**Re: Auto Nation – 9100 Pan Am Freeway NE  
Erosion and Sediment Control Plan  
Engineer’s Stamp Date 6/30/2021 (B18E027)**

Based upon the information provided in your submittal received 7/26/2021, the above-referenced ESC Plan cannot be approved for Building Permit or Work Order until the following Comments are addressed.

AUTO NATION ALBUQUERQUE, NM		DRAWN BY pm
	TEMPORARY EROSION CONTROL PLAN		DATE 6-30-21
	 5571 MIDWAY PARK BL NE ALBUQUERQUE, NEW MEXICO 87109 (505) 858-3100 www.tierrawestllc.com		DRAWING 2021010-SP
	SW-1		SHEET # JOB # 2021010

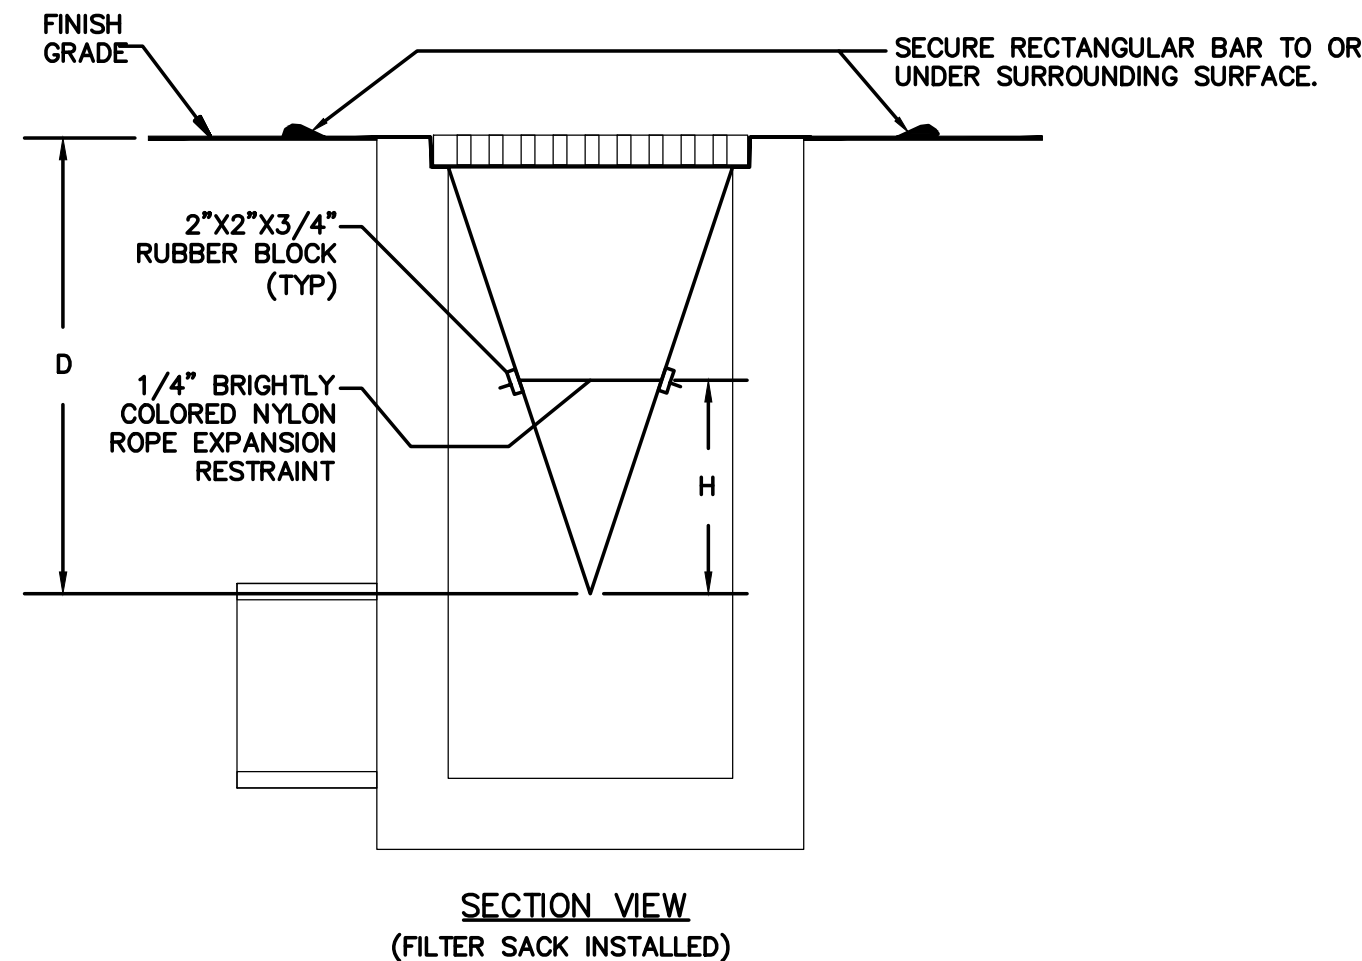
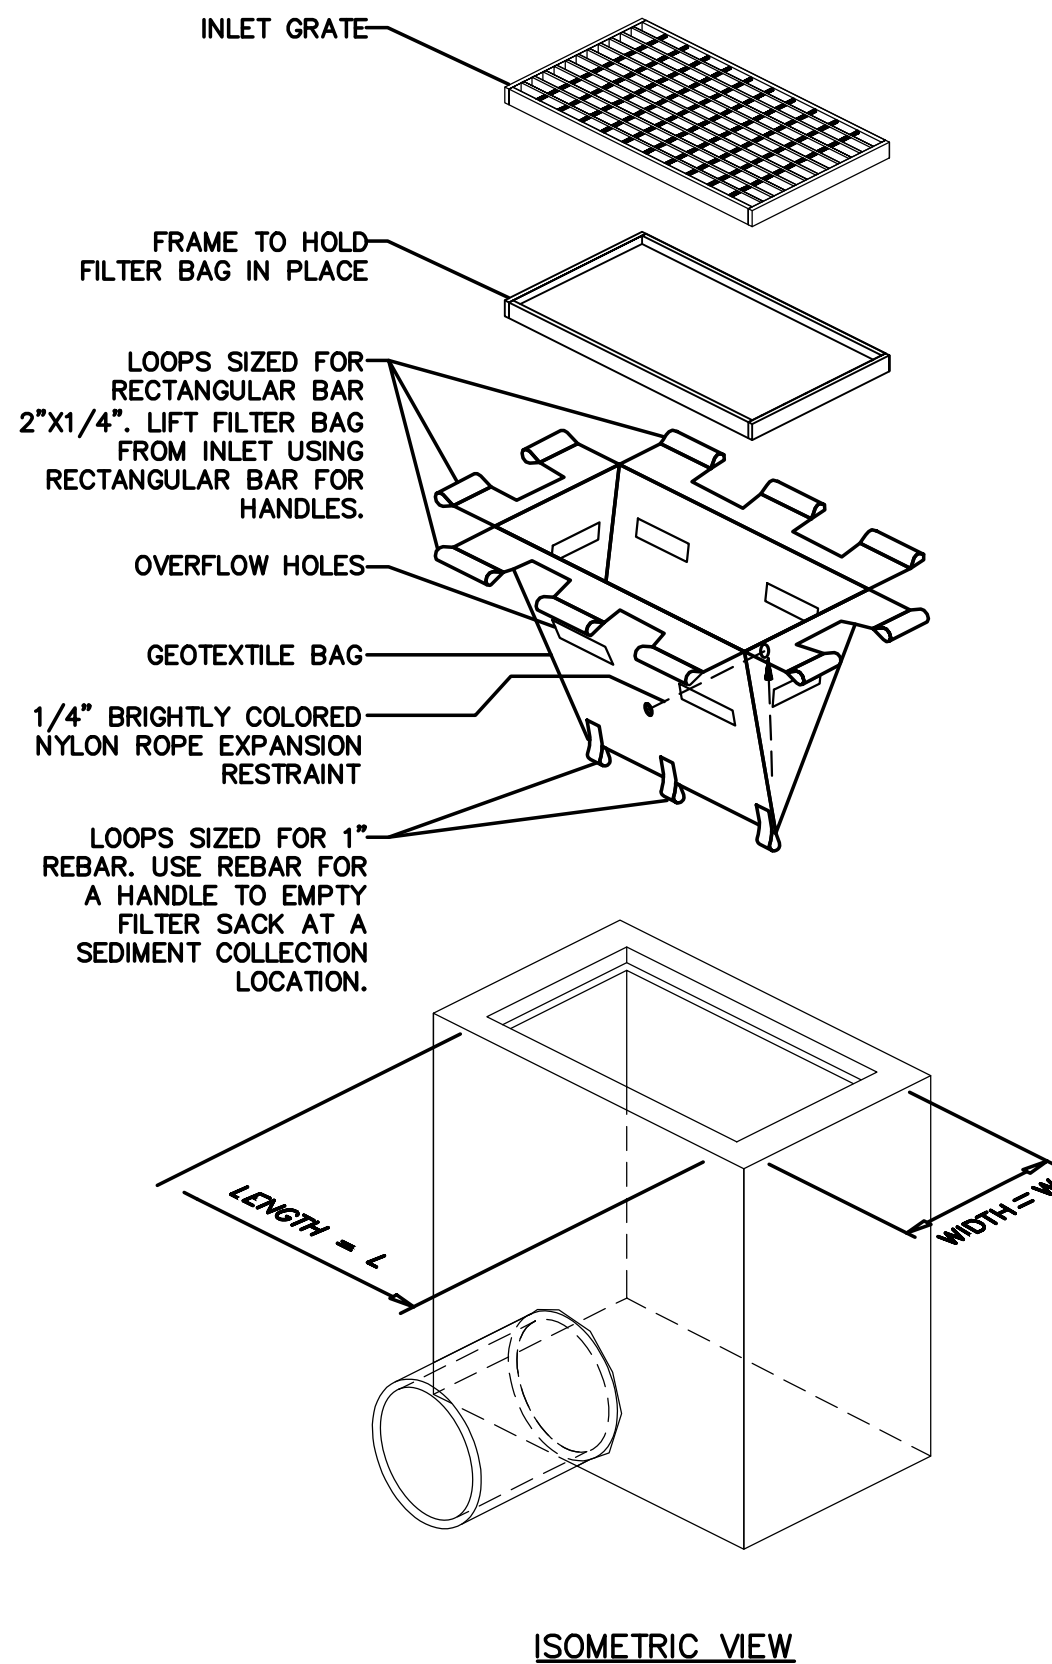
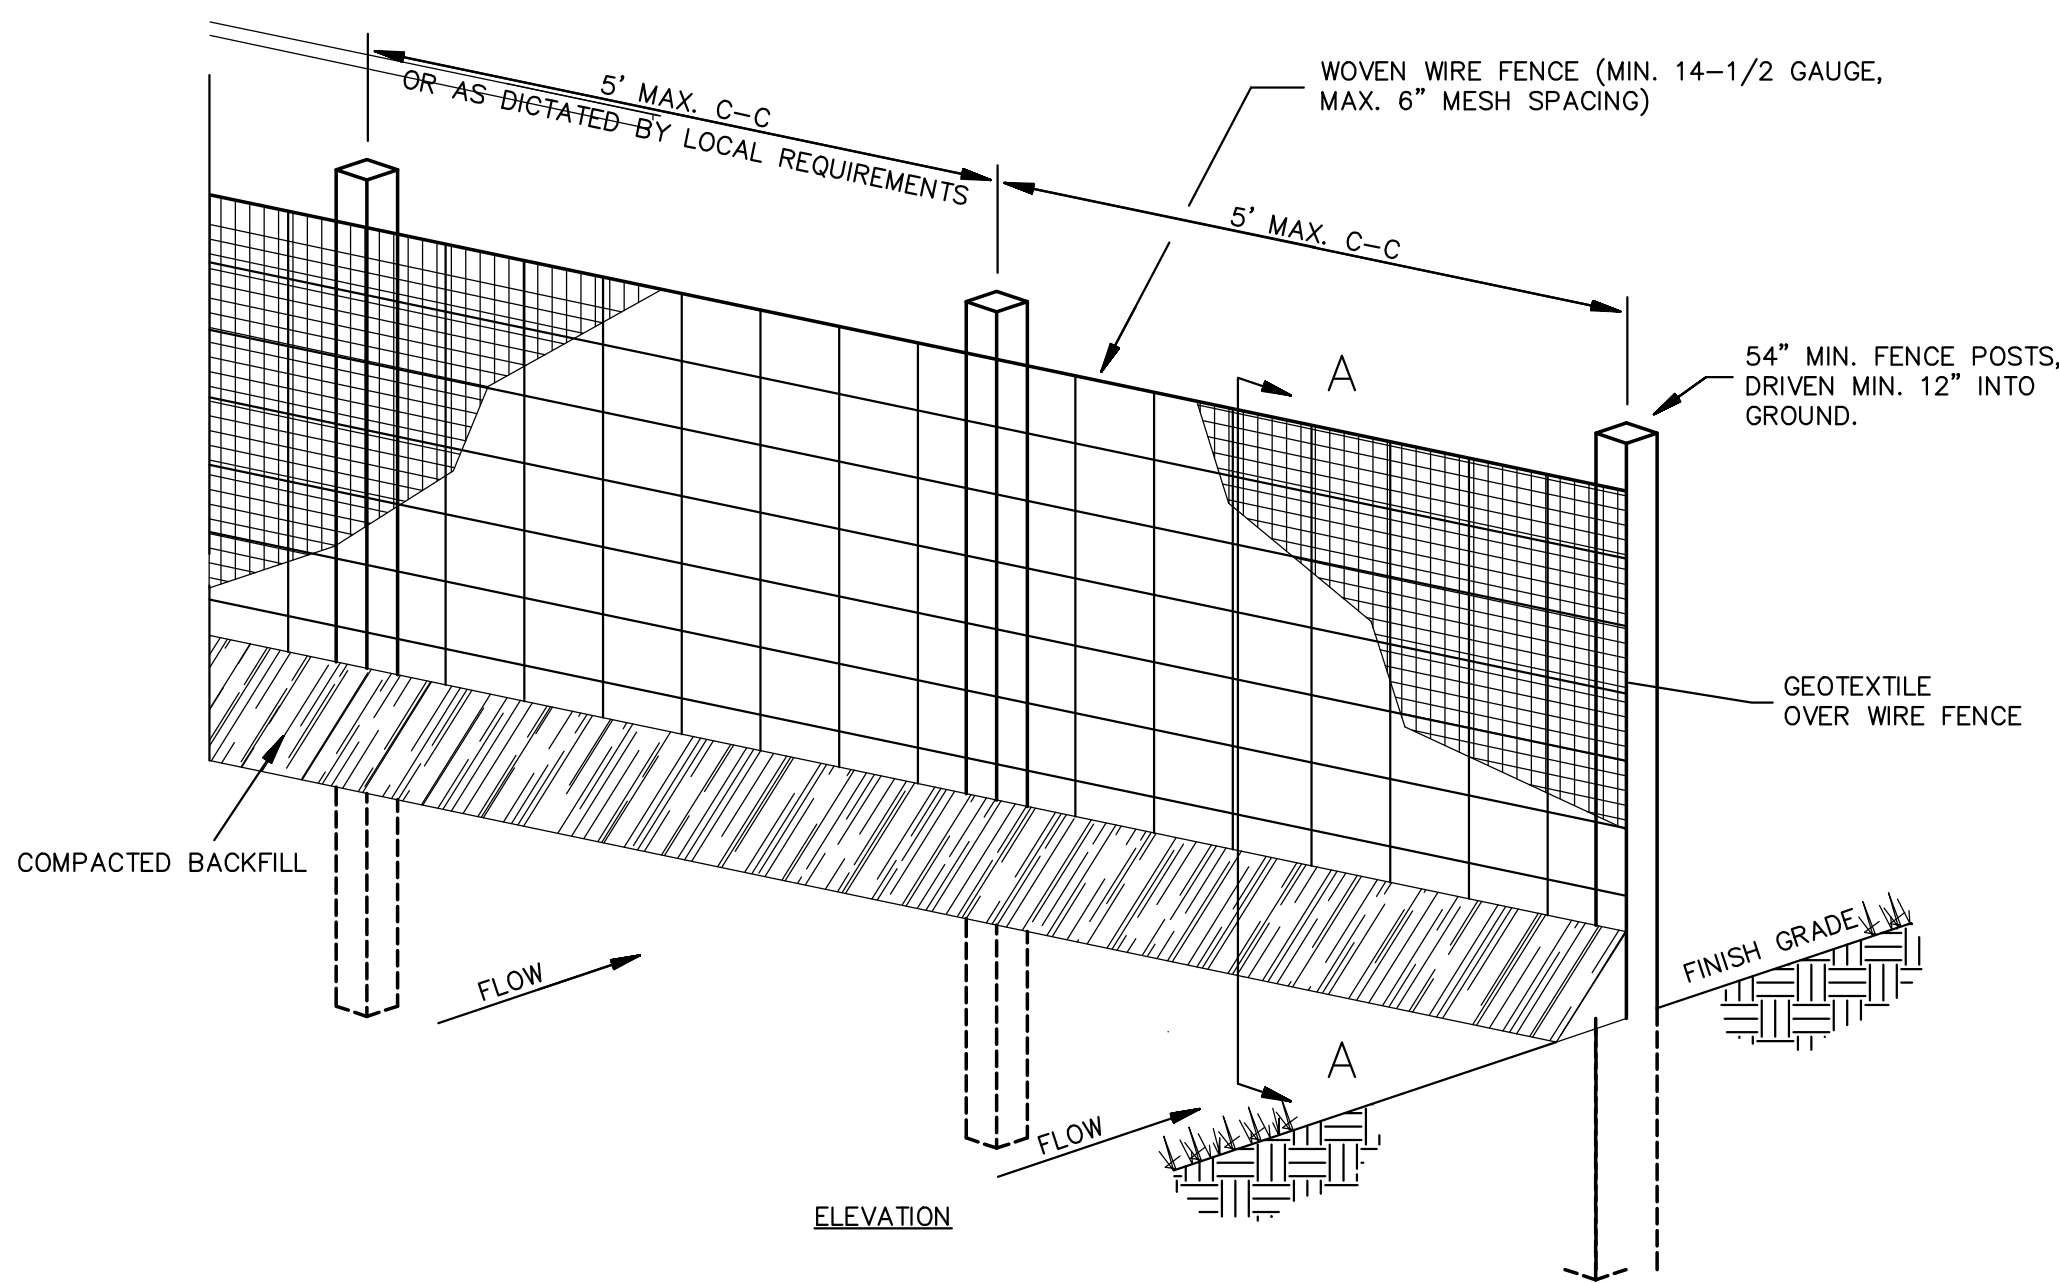
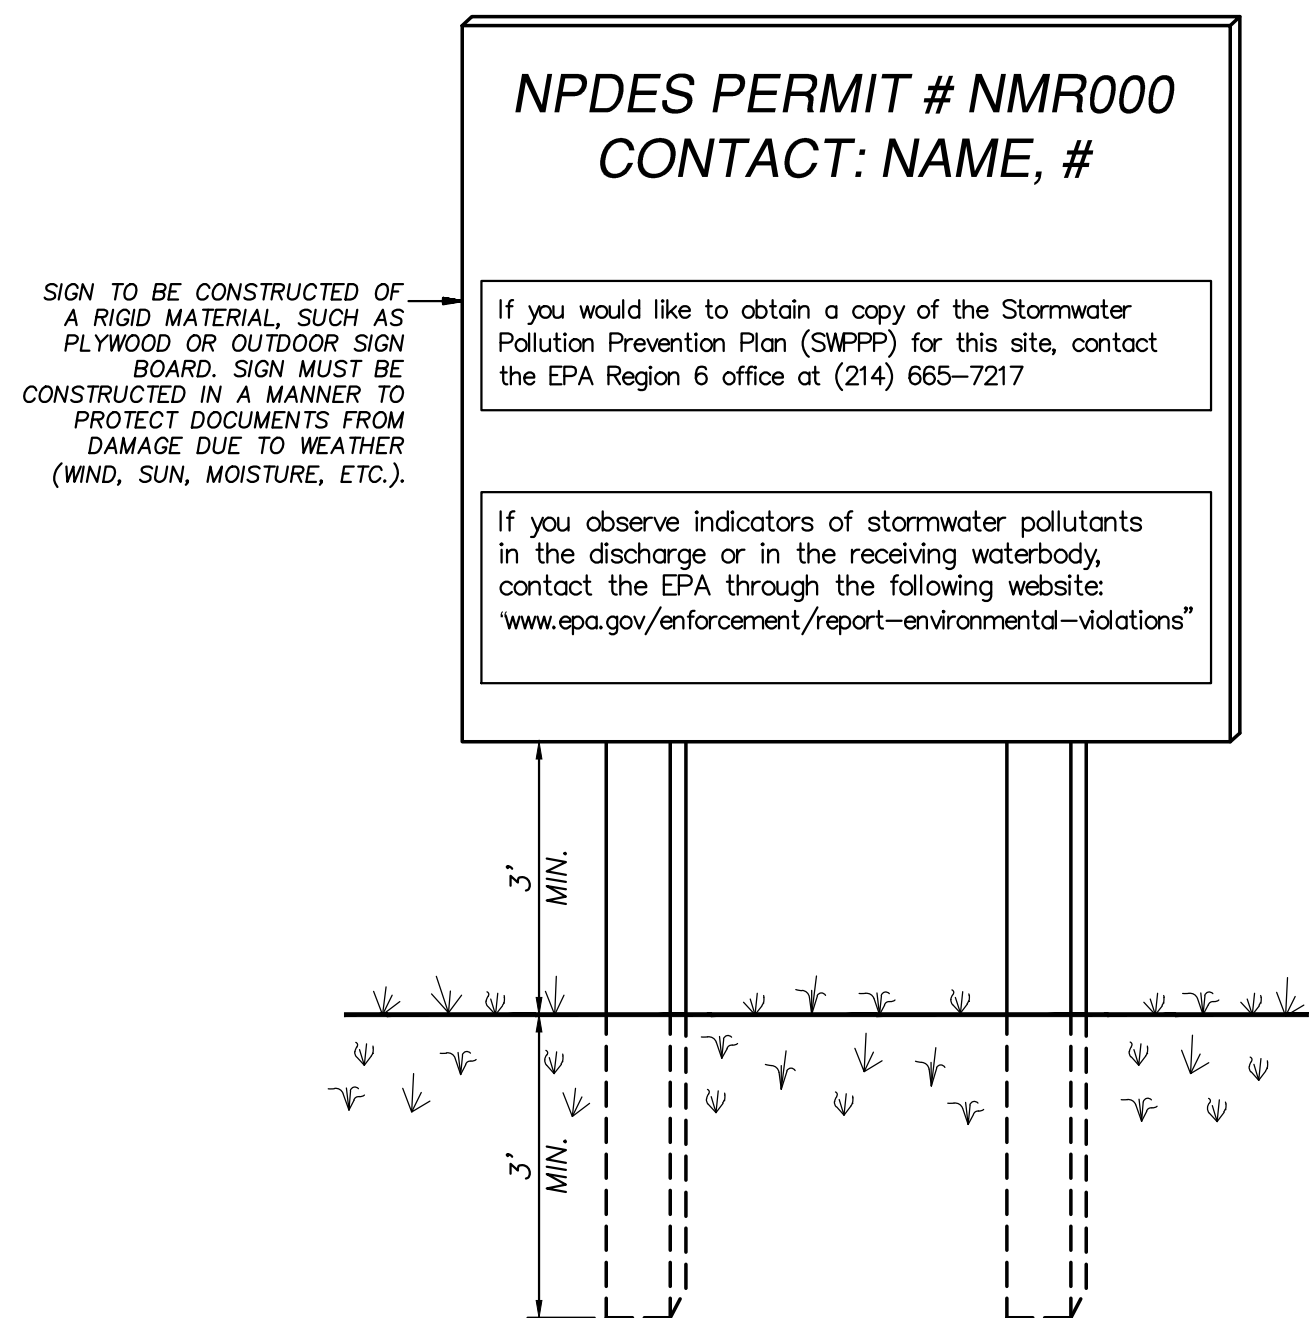
1. I can’t tell the difference between building, sidewalk, asphalt, and dirt on the ESC Plan. These structures must be clearly identified in the SWPPP per CGP 7.2.4.b.v. The same information is required in the ESC Application. You may include a copy of the Site Plan in both the SWPPP and in the ESC Application to address this requirement.

3. The “Nature and Extent of Construction Activities” on sheet SW-1 doesn’t include the building or landscaping. The disturbed area of 5.5 acres doesn’t match the NOI’s 7.25 acres. The description of Construction Support Activities may be omitted unless those areas of land-disturbing activities will occur off-site is which case the sites must be shown on the plan. Delete the paragraph on sheet SW-1 that calls for annual inspections and replace it with the inspection frequency required by the CGP. Delete the sentence that says an NOI may be transferred under the heading of “NOT Termination” since that is prohibited explicitly by CGP Appendix I.12.3.

4. The Sequence of Construction on sheet SW-1 also omits the building and the landscaping and talks about onsite roadway and installation of additional silt fence to keep sediment out of onsite roadways, which seems to apply to a different project. Under construction sequencing; 8) where are the onsite inlets? 9) Where is the onsite roadway? 10) Sediment traps will turn into permanent ponds and shouldn’t be removed. Where will the additional silt fence go?

5. The description of predevelopment conditions should say the site is covered by asphaltic paving, and the undisturbed natural state is uncompacted soil with 30% cover by native grasses and shrubs. AC removal and disposal should be added to the descriptions of the nature and the sequence of the construction project.
